Subject: RE: Y/105/19/PL and Y/106/19/L

Following our telephone conversation in April and previous email correspondence regarding the planning and listed building application for Stakers Farm Barns, we are intending to make the following amendments to the application to secure a positive determination:

Drawing Title
Existing and Proposed Elevations - Barn 1

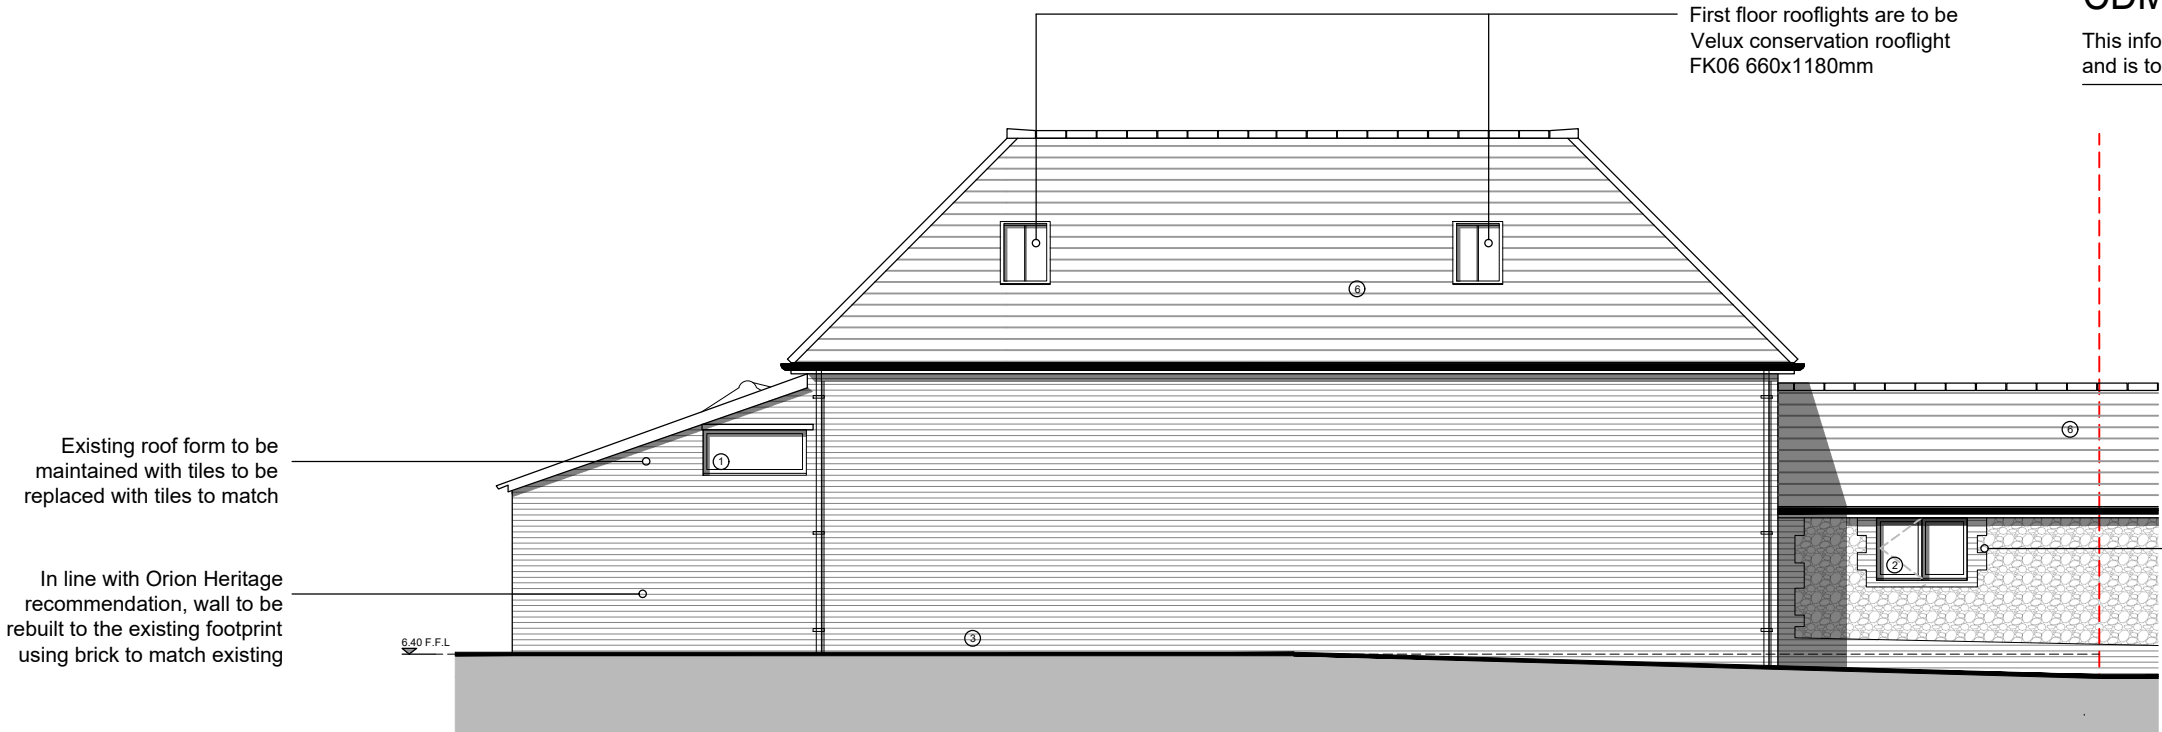
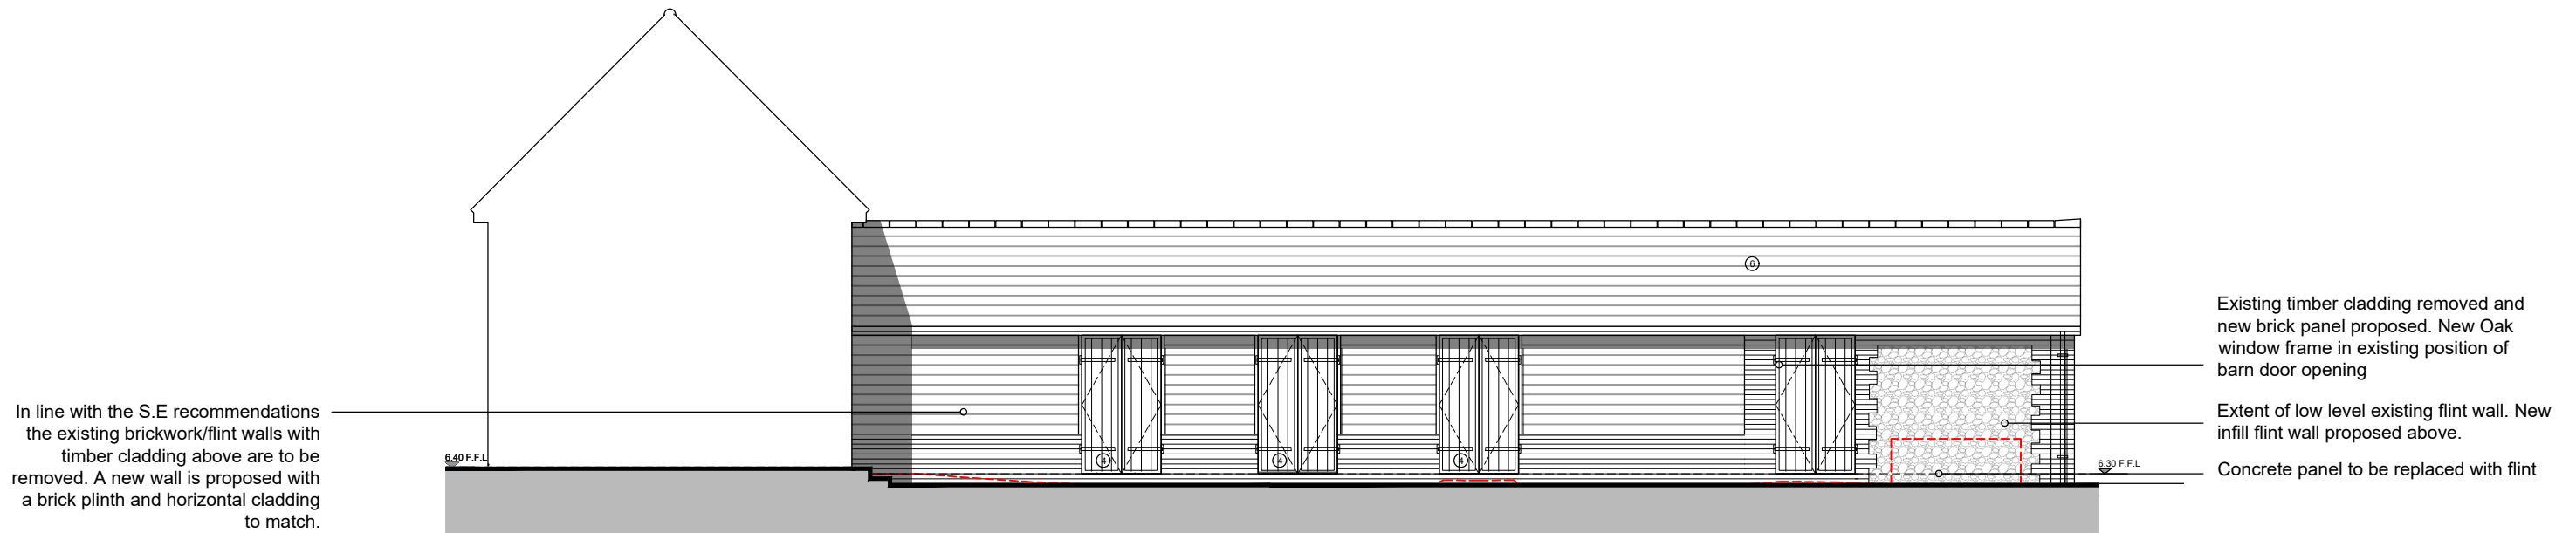
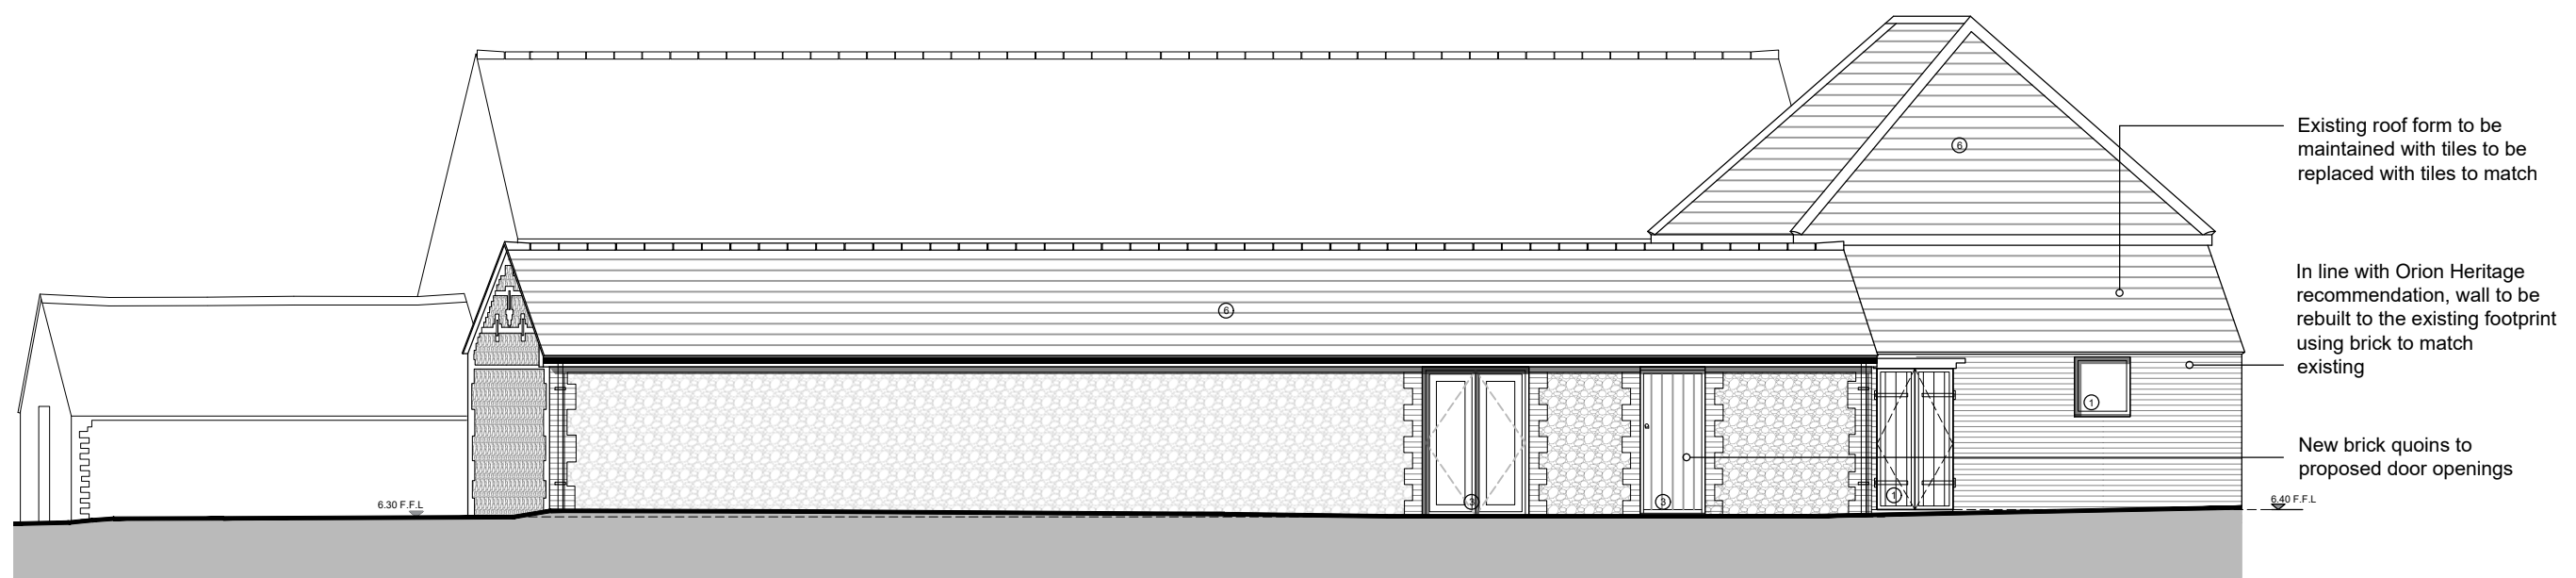
South elevation – we will amend the proposed alterations to the single storey element and reduce the amount of glazing, ensuring that this elevation is changed as little as possible from the existing situation.
